**From:** Jeff Tarling  
**To:** Jean Fraser  
**CC:** David Margolis-Pineo  
**Date:** 1/22/2014 2:49 PM  
**Subject:** 118 Congress Street Project

118 Congress Street project / tree & landscape review comments:

Tree & Landscape review comments for the proposed 118 Congress Street project:

LANDSCAPE PLAN
SCALE: 1" = 8'-0"

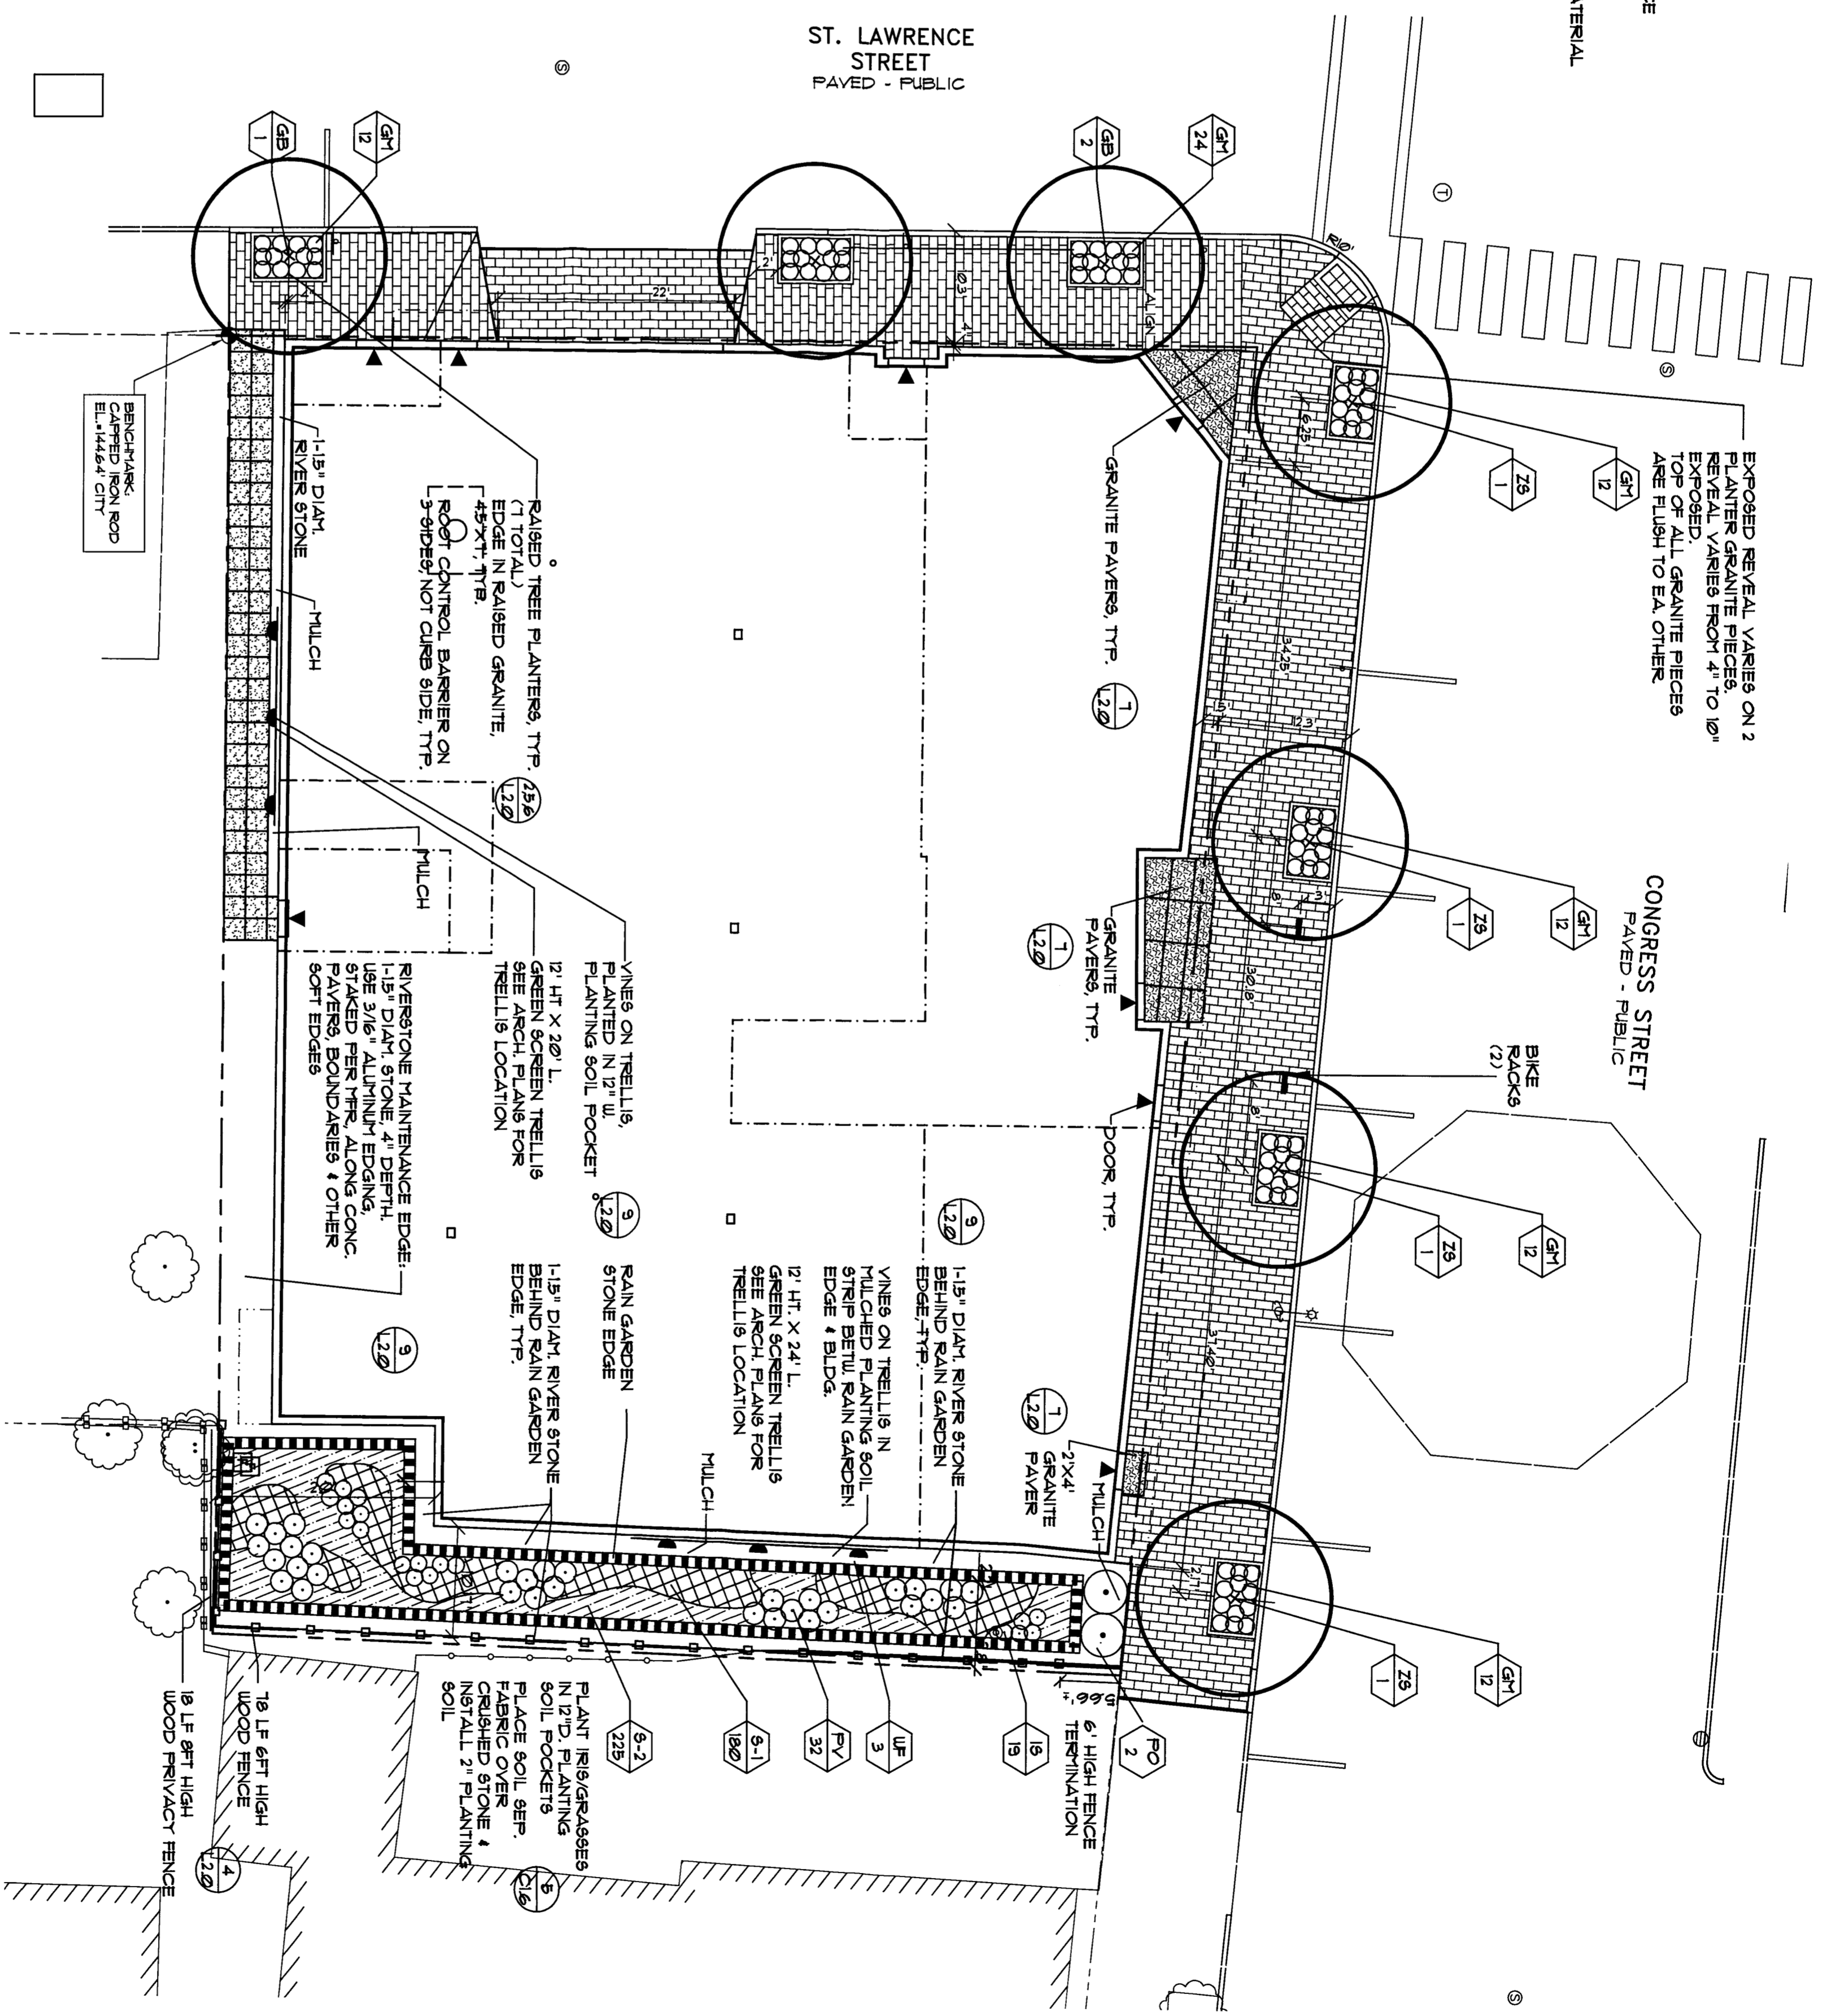
**a) Street-trees** - the project proposes to plant (6) street trees, (4) along Congress Street, 'save' the existing Pin Oak and plant (2) new on Saint Lawrence Street. Updated plan shows the trees planted in raised granite tree wells with herbaceous planting. If on-street parking is proposed, the tree spacing or setback away from the curb to prevent the opening of car doors is important. The trees can be placed to match the in-between on-street parking, making sure there is good access to the sidewalk from parked cars. The residential tree standard of one tree per unit would also be a condition. Building overhangs over the public way should be discouraged to allow the street tree growth.

**Tree types** - It would be ideal if the tree types along Congress Street are all the same species. I would recommend the Columnar 'Musashino' Zelkova to be ideal due to the narrow space. See <http://www.jfschmidt.com/articles/musashino> and photo below.

The 'Red Sunset' Maple crown shape is too broad for this space. Along Saint Lawrence Street again a more narrow tree is needed, it could be Ginkgo 'Magyar' or 'Autumn Gold' cultivar (seedless), due to narrow sidewalk space. (photo 'Musashino' Zelkova, narrow vase shape crown)

**b) Landscape** - The recent revision adds herbaceous planting to the tree planters and the 'backyard' / rain-garden edge. Additional screening to the adjacent property should be considered, this might be achieved by adding higher branching landscape planting or higher fencing (5'). The rain-garden planting with mostly herbaceous plant material will reach a low height. It does not appear to meet the B-1 Zone landscape standard ( i ) " A densely planted buffer and / or fencing will be required to protect neighboring properties..." Suggestions could including some taller shrub plants along with a higher wooden fence. The Green Wall proposed will also help screen the building. Additional green-wall / landscape planting could be used on the West elevation to the left of the garage door, this area seems blank; and to the left of the center door on Congress Street away from the overhead canopy.

1 NORTH ELEVATION
1/8" = 1'-0"

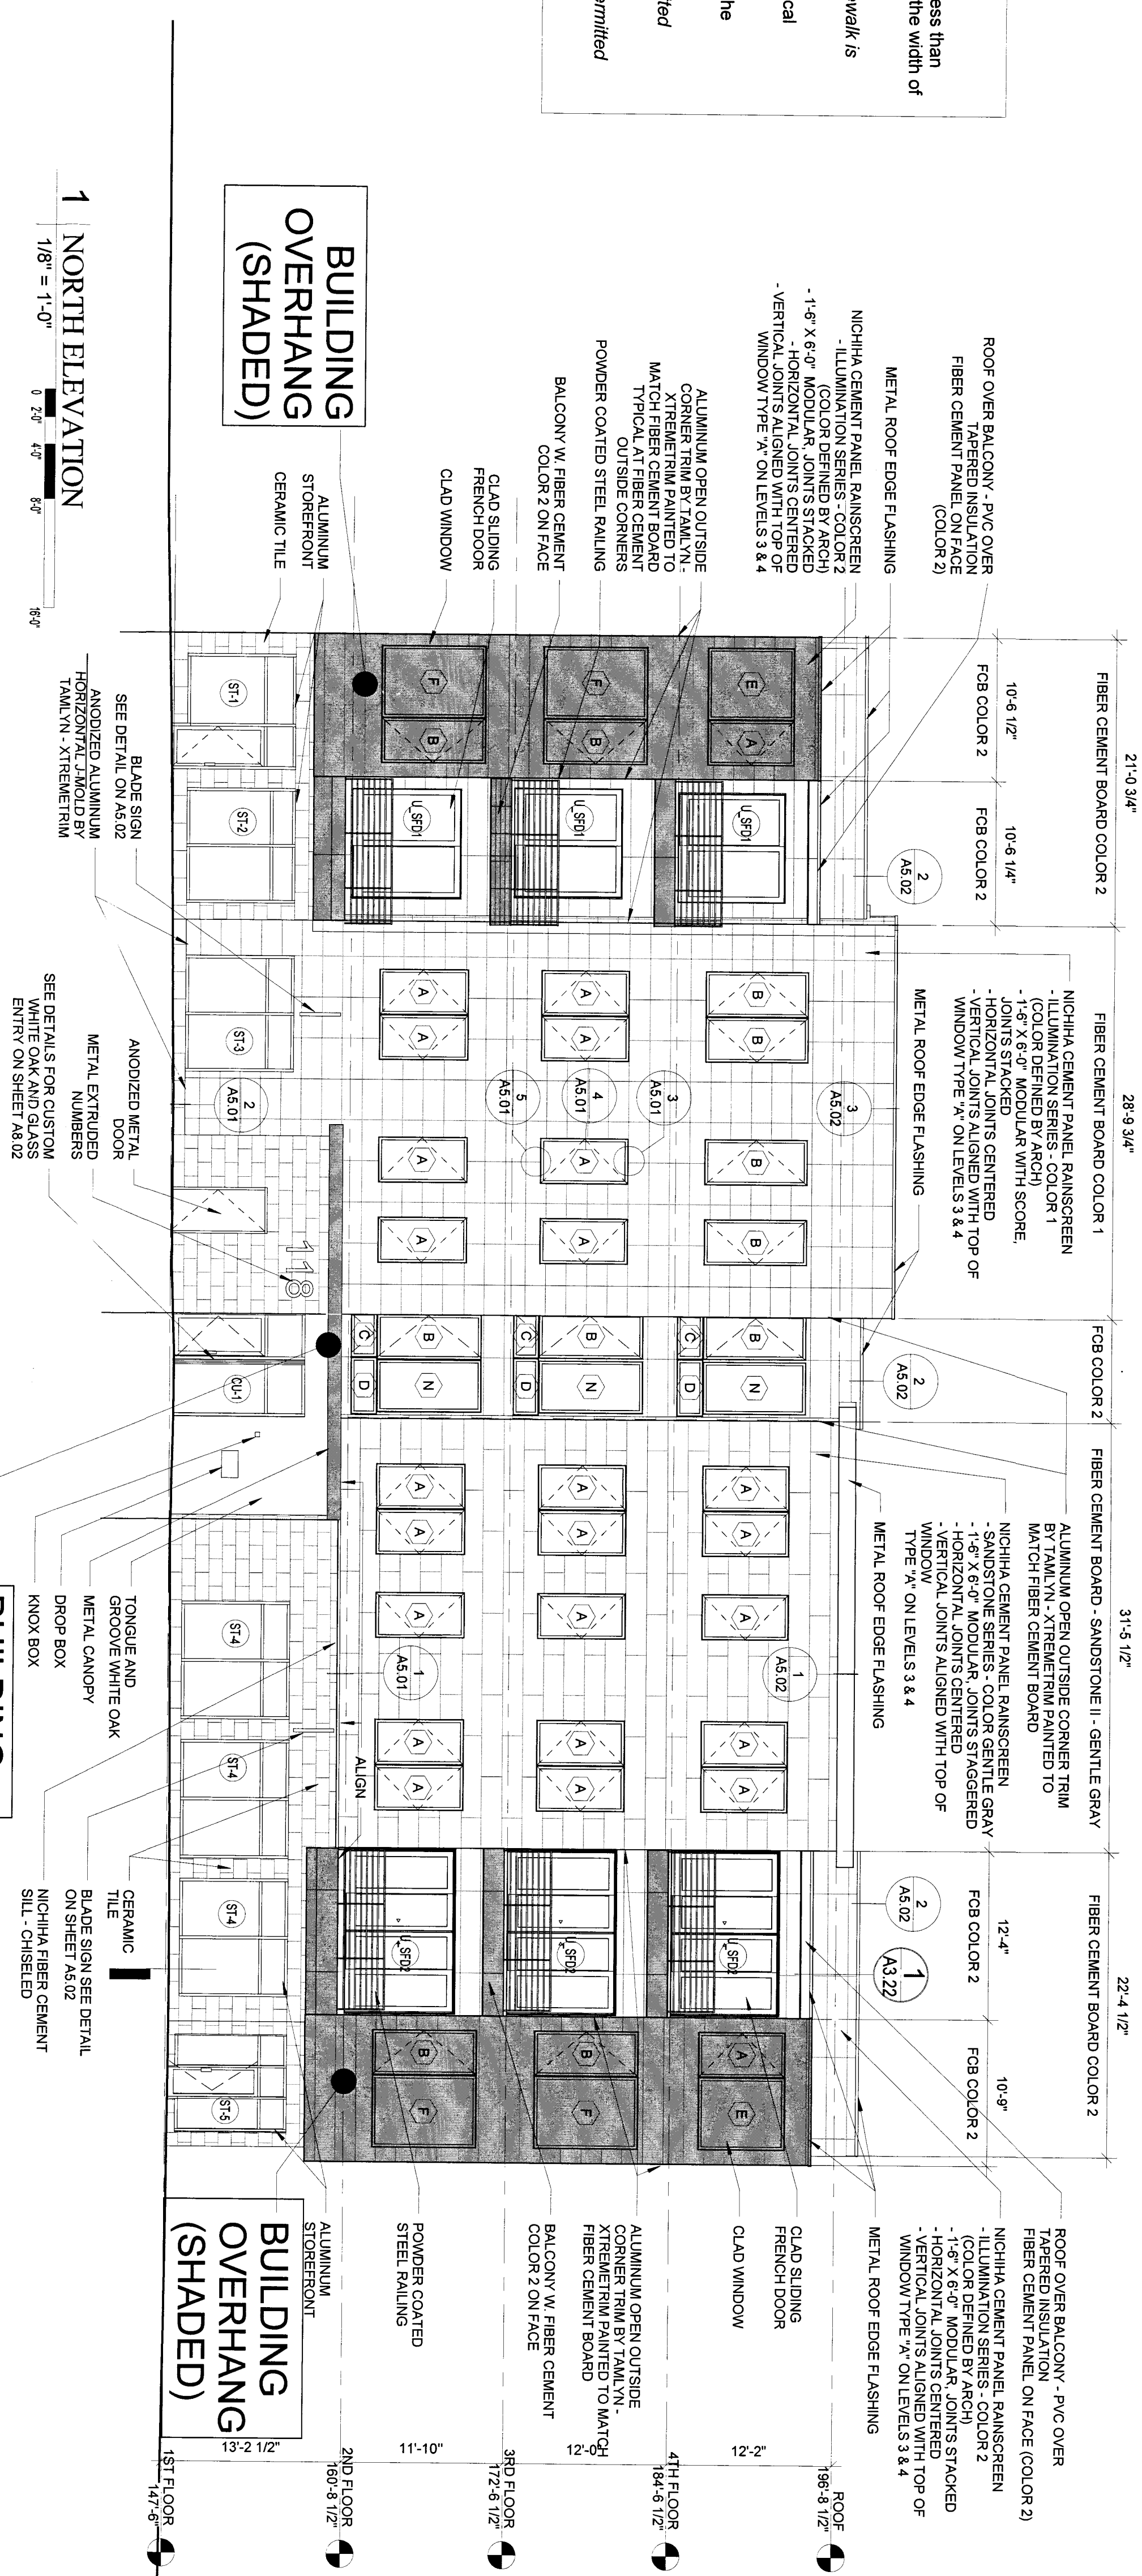
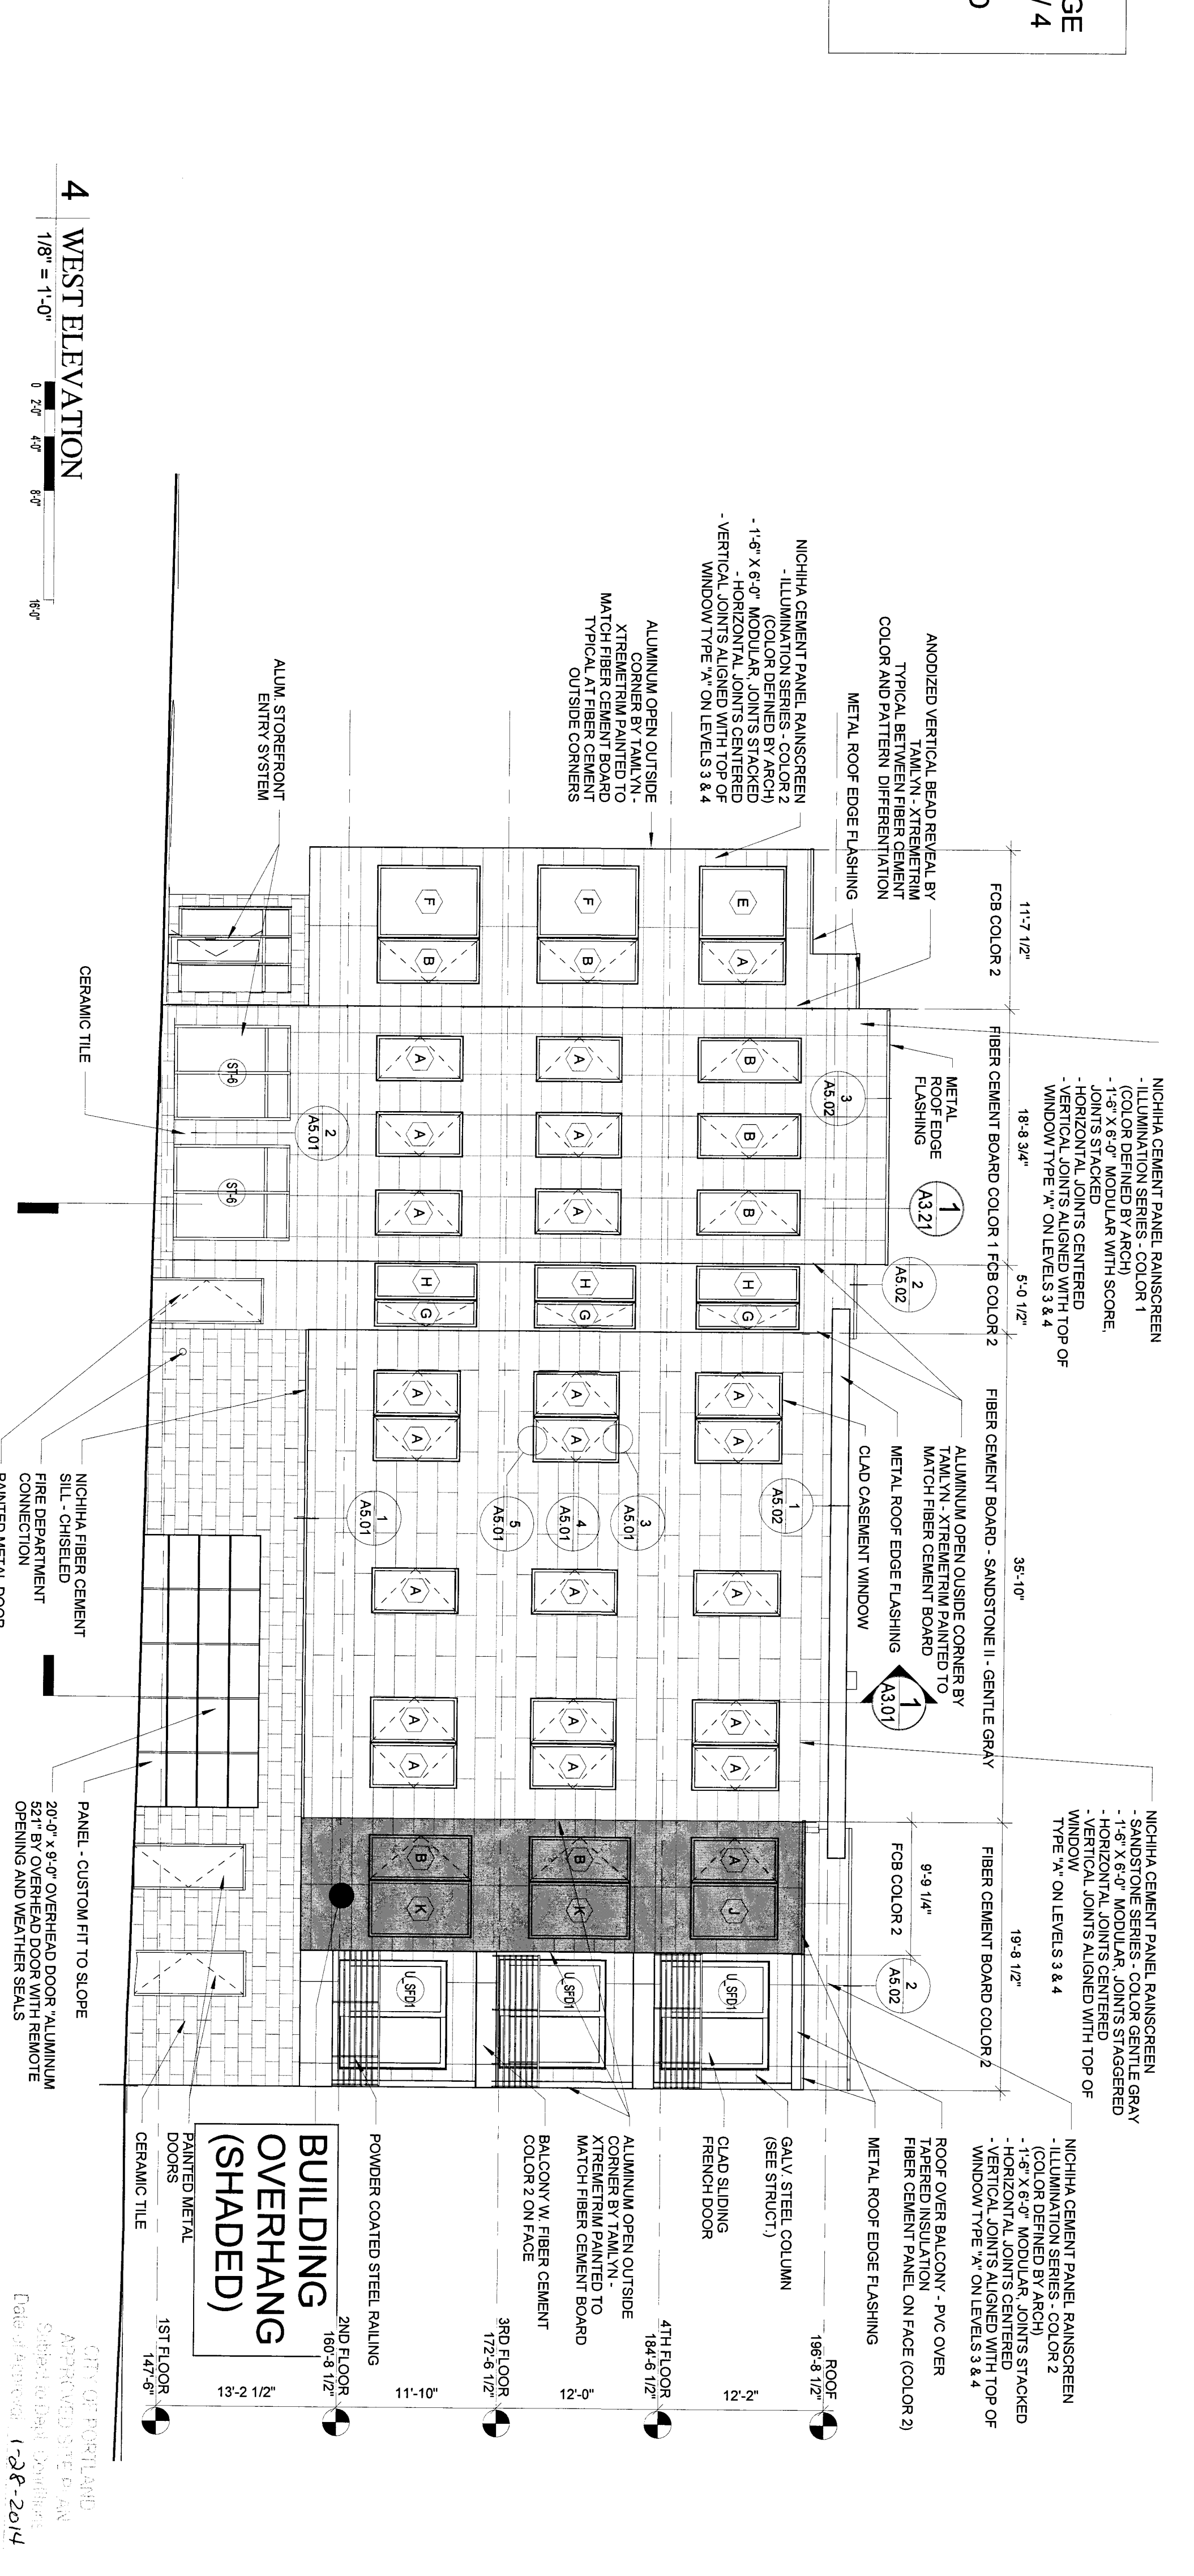
- \* Proposed building overhang over the sidewalk seriously effect street-tree growth and are strongly opposed as shown. The building overhang eliminates ALL future shade tree / street tree possibilities and is unacceptable as it changes the character of Congress Street and the Eastern Promenade.
